# City of Albuquerque

February 9, 1993

RE: DRAINAGE PLAN FOR PLACITA DE ABOGADO (J14-D88A) ENGINEER'S STAMP  
DATED 2/2/93.

GRADING & DRAINAGE PLAN
PLACITA de ABOGADO
RON A. BELL
 SEVENTH ST. & FRUIT AVE. N.W.
 ALBUQUERQUE, NEW MEXICO

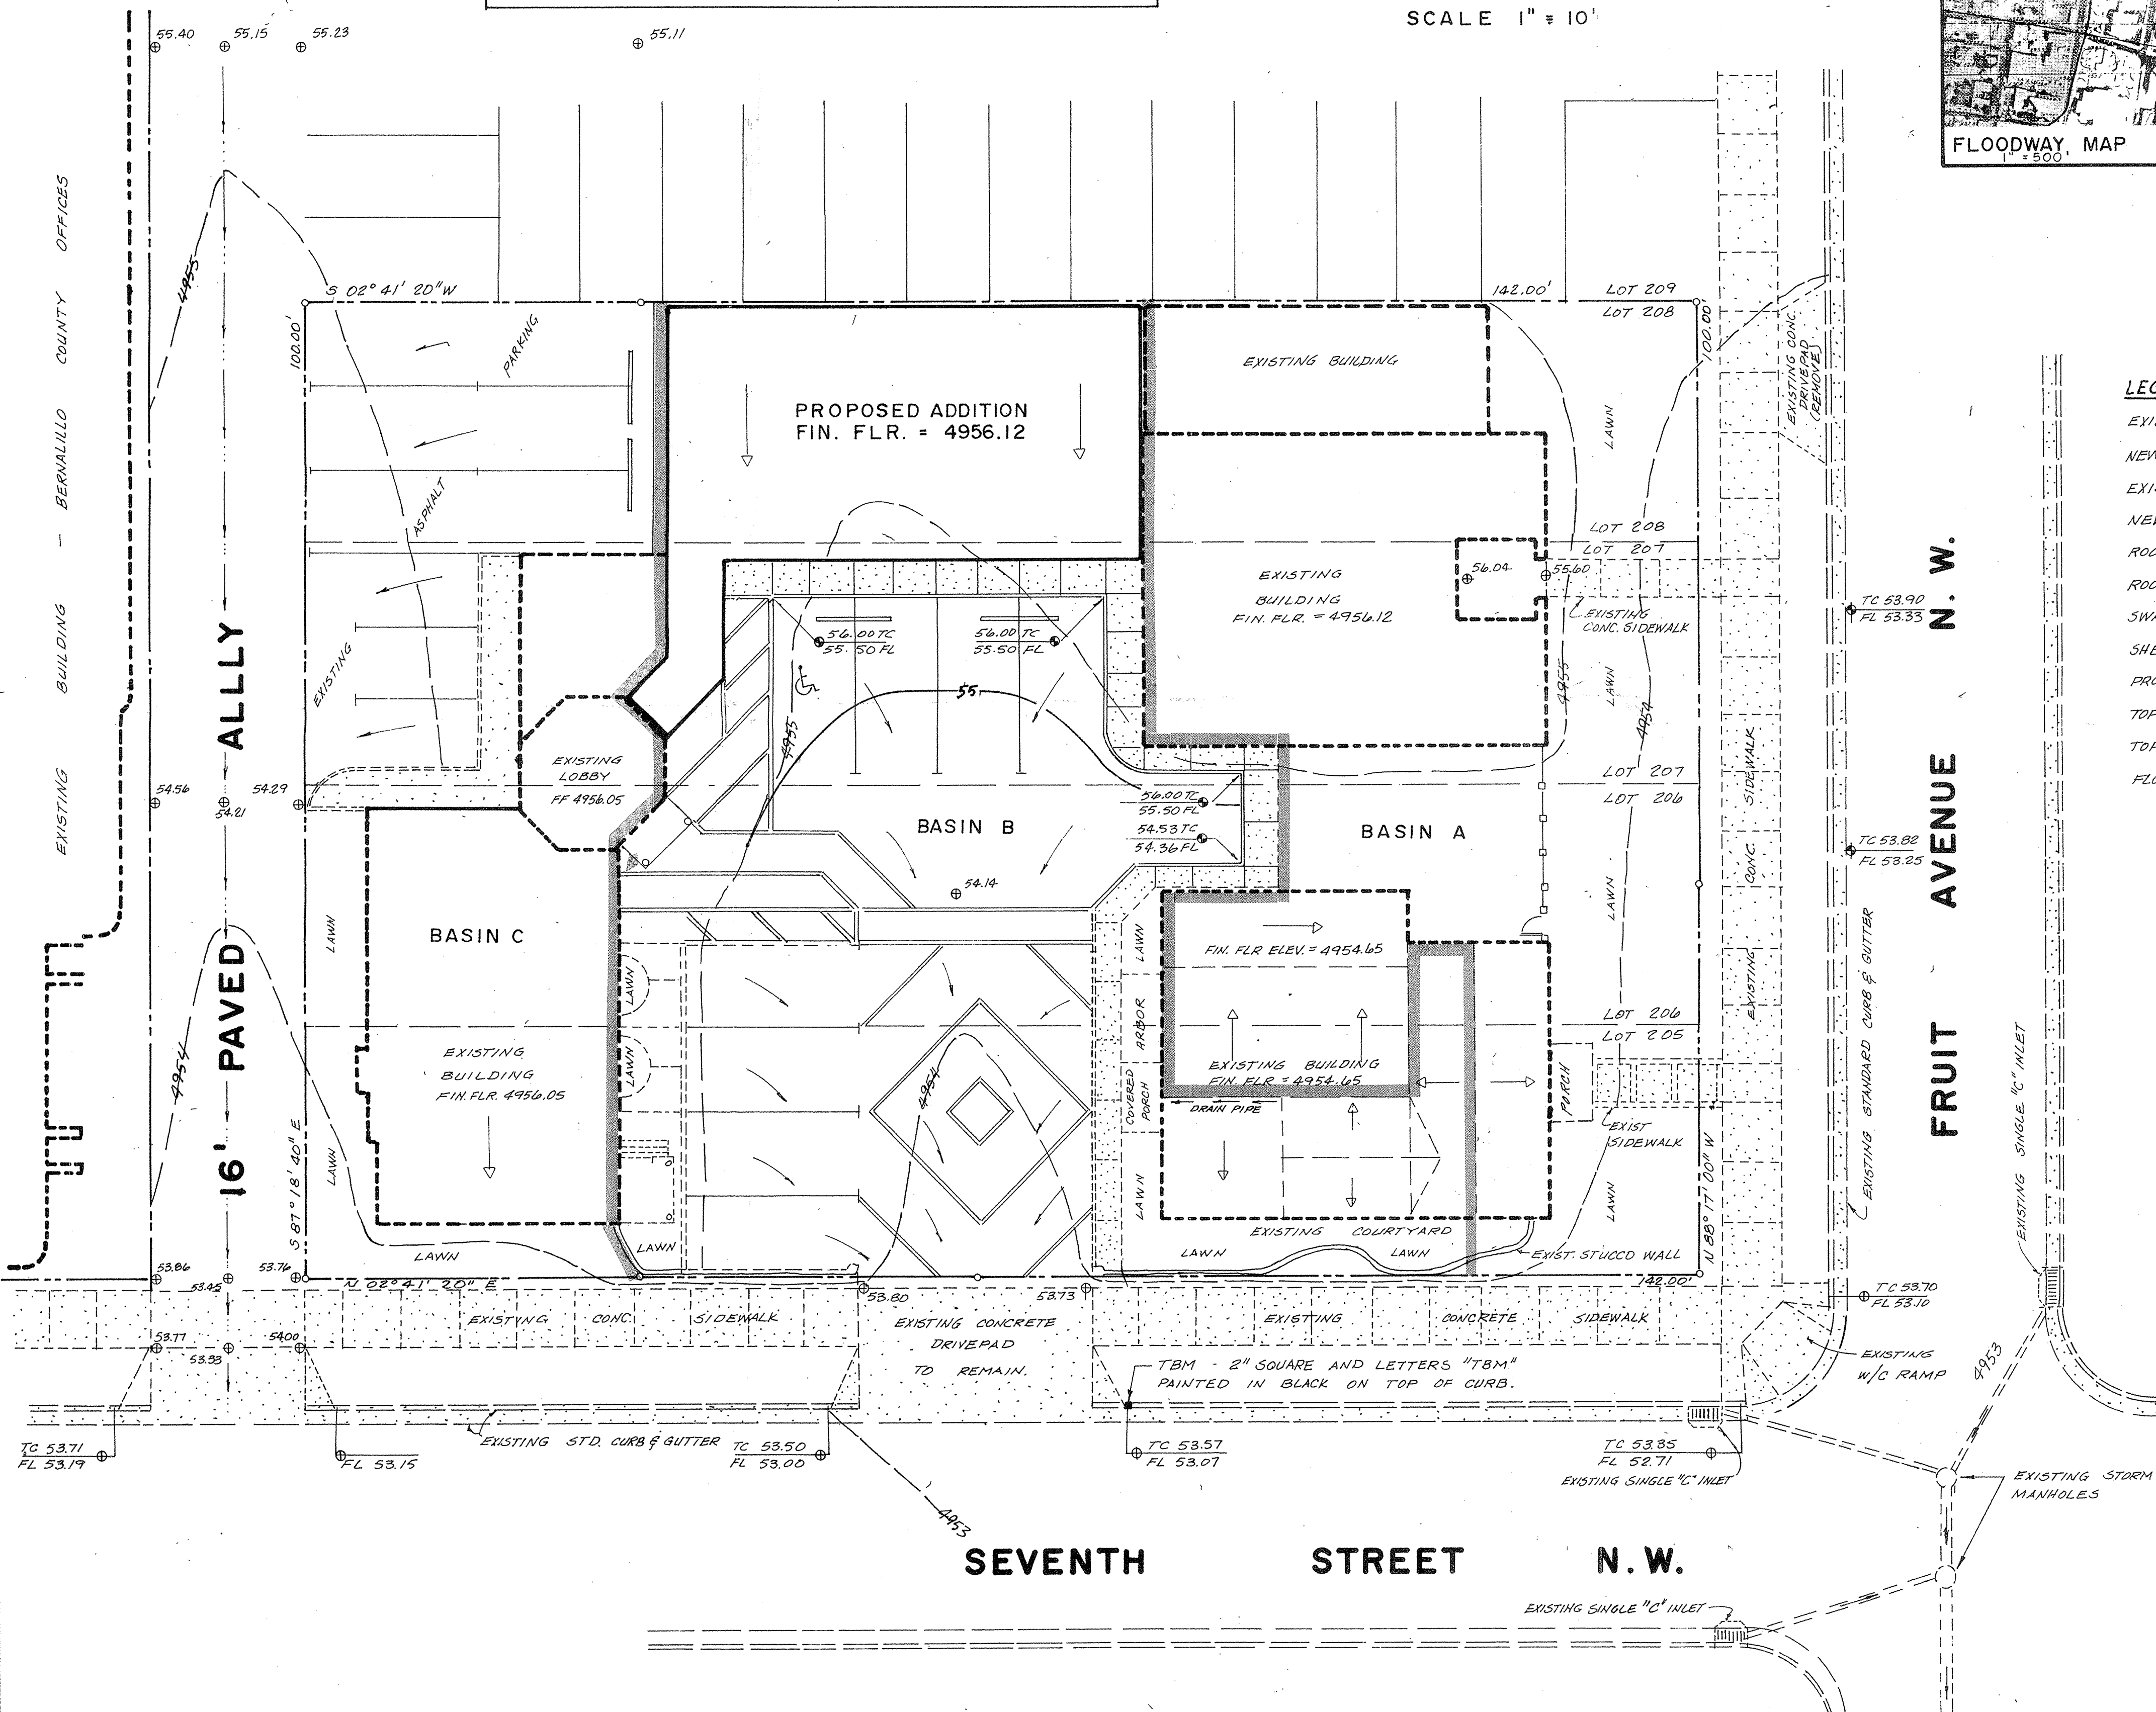
1. Cross lot-line drainage easement will be required for drainage from lot 207 thru 206. Cross-lot-line drainage for other lots will not be required because they straddle the buildings.
2. Please identify where the roof run-off from the newly constructed addition is being routed to. If it is routed onto lot 209, then permission from the adjacent property owner will be required, or provision must be made to route it within lot 208.
